Consultation Response KC Landscape

Planning Number:	2025/93532		
Proposal:	Discharge of details reserved by conditions 6 (site preparation and clearance), 8 (BEMP), 9 (landscaping), 11 (fencing), 12 (WSI), 14 (shared access), 16 (access road), 19 (wheel bath), 22 (Access Management Plan), 23 (parking), 49 (surface water discharge), 59 (delivery HGV route) on previous permission 2023/91280 for quarrying operations for the extraction of clay, shale and incidental coal and subsequent restoration by means of importation of inert wastes		
Location:	Bromley Farm Quarry, Barnsley Road, Upper Cumberworth, Huddersfield, HD8 8PD		
DEVELOPER/APPLICANT/AGENT:	Silkstone Environmental Ltd		
Planning Officer:	Farzana Tabasum		
Date Responded:	24/04/26	Responding Officer:	AR
Site Area (Hectares)	8.4 Hec	Responding Ref:	PP71

NOTES/COMMENTS: COND 9 – Landscaping

We have reviewed the following information submitted in relation to application ref. 2023/91280 and the above condition : 9.

**SURFACE WATER
MANAGEMENT SCHEME**

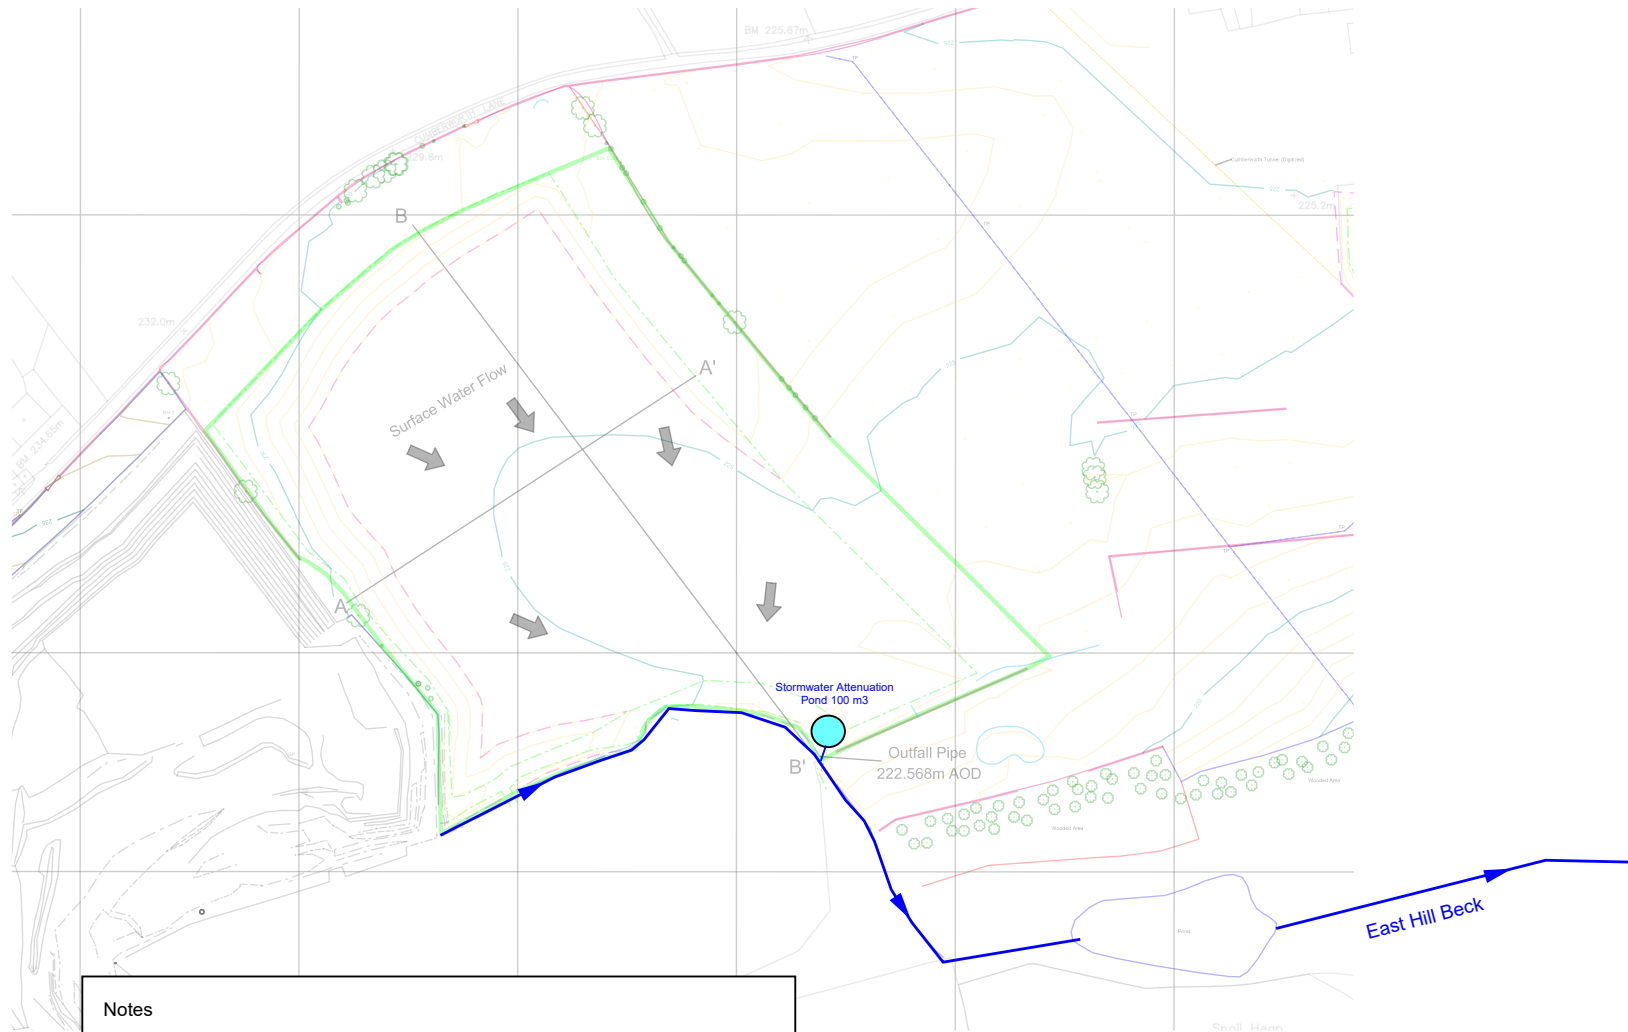
Post restoration drainage has been considered and included into the annual aftercare period once the ground has settled and been assessed. Drainage measures described include incorporating surface water filtration, interception ditches and attenuation through the existing pond. Ongoing monitoring and adaptive management during the aftercare period are also addressed.

*See Restoration and Landscapeing Report – Item10 and Management of habitats Item 9
And See Drawing 261/01/02 – surface water Management Scheme.*
